## Conservation Area Advisory Committee

Meeting Date : 4th September

| WA/54/17/PL | Single storey side extension to form new entrance lobby & disabled WC facilities. This application affects the character & appearance of the Walberton Village Conservation Area. | Walberton Baptist Church<br>The Street<br>Walberton<br><br>BN18 0PG |

PROPOSED ELEVATIONS

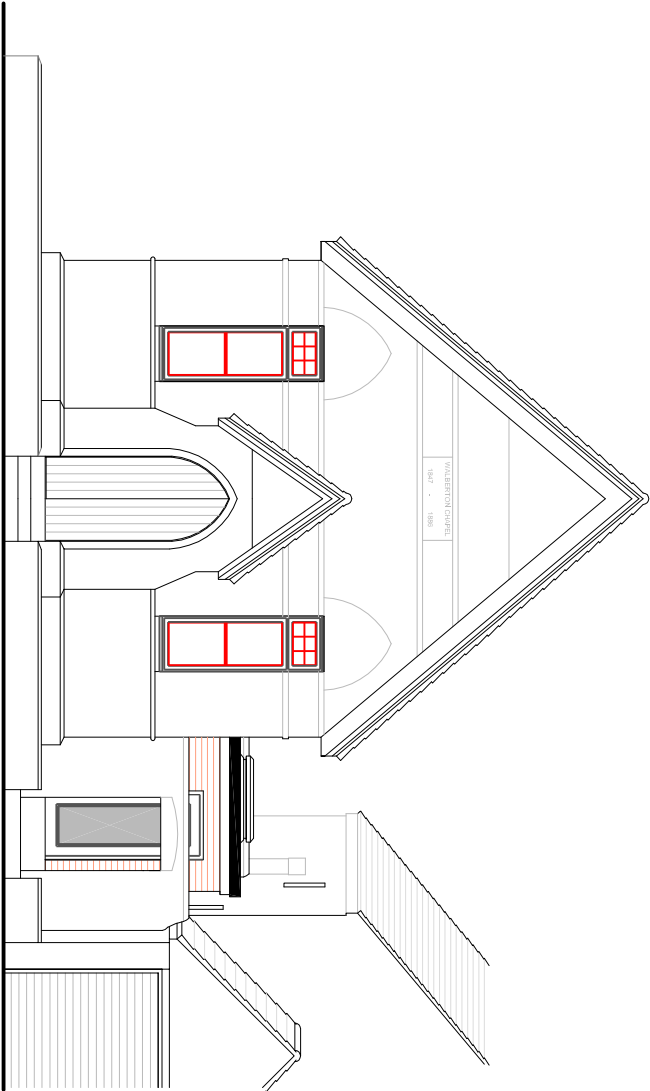
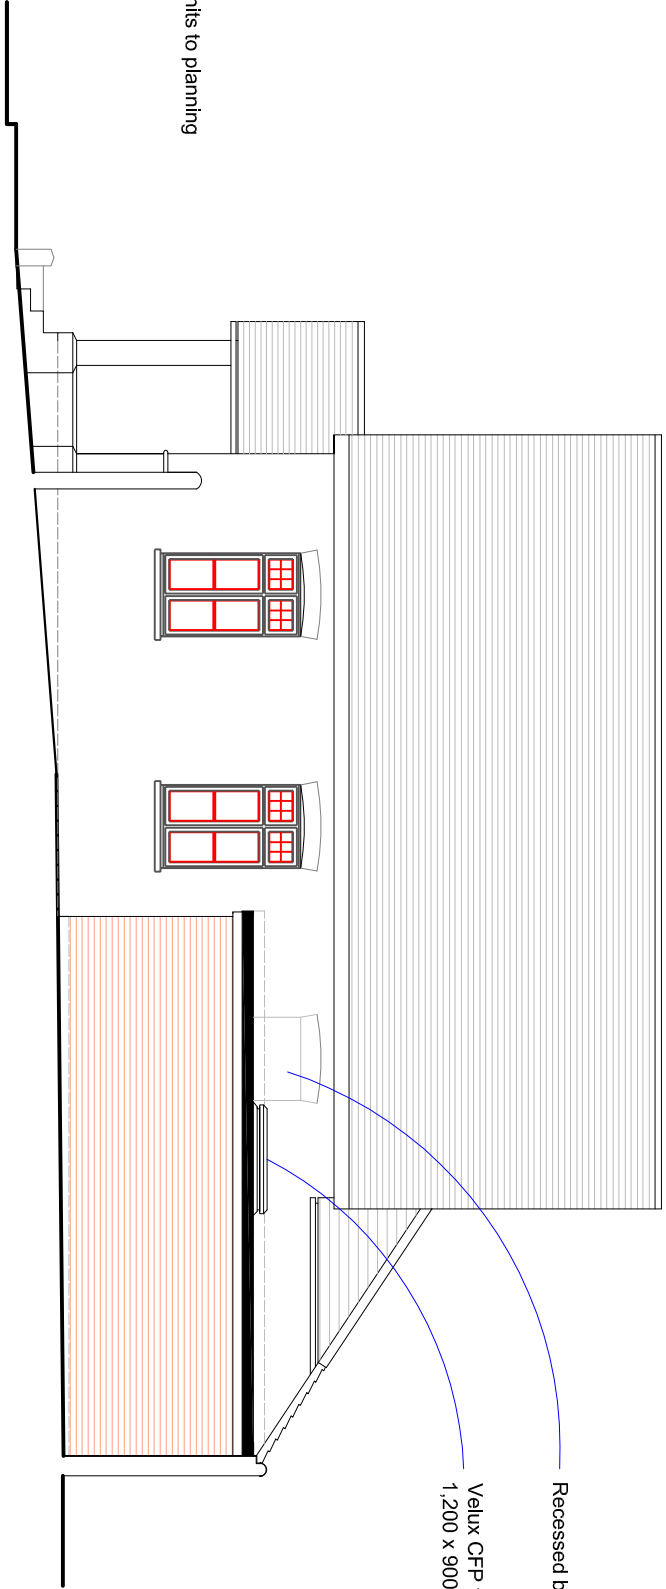
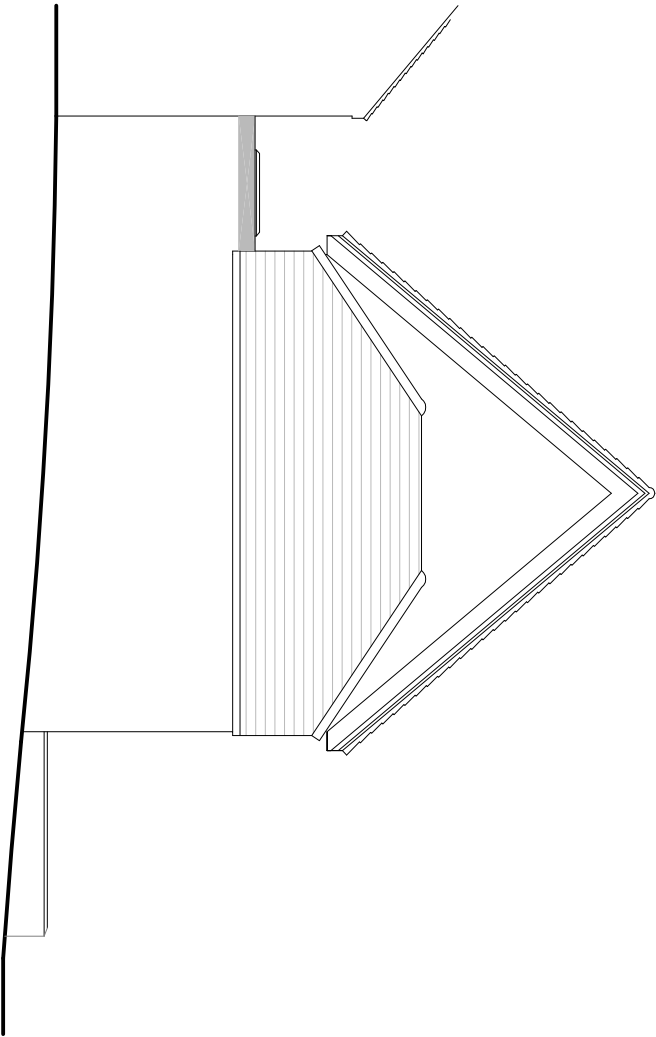
Suggested Conditions: *The design & location of the proposed extension in the context of its proposed use. However there are concerns regarding the design & appearance of the roof which would be seen from the street scene. The front elevation could be improved by the use of a parapet wall & coping*
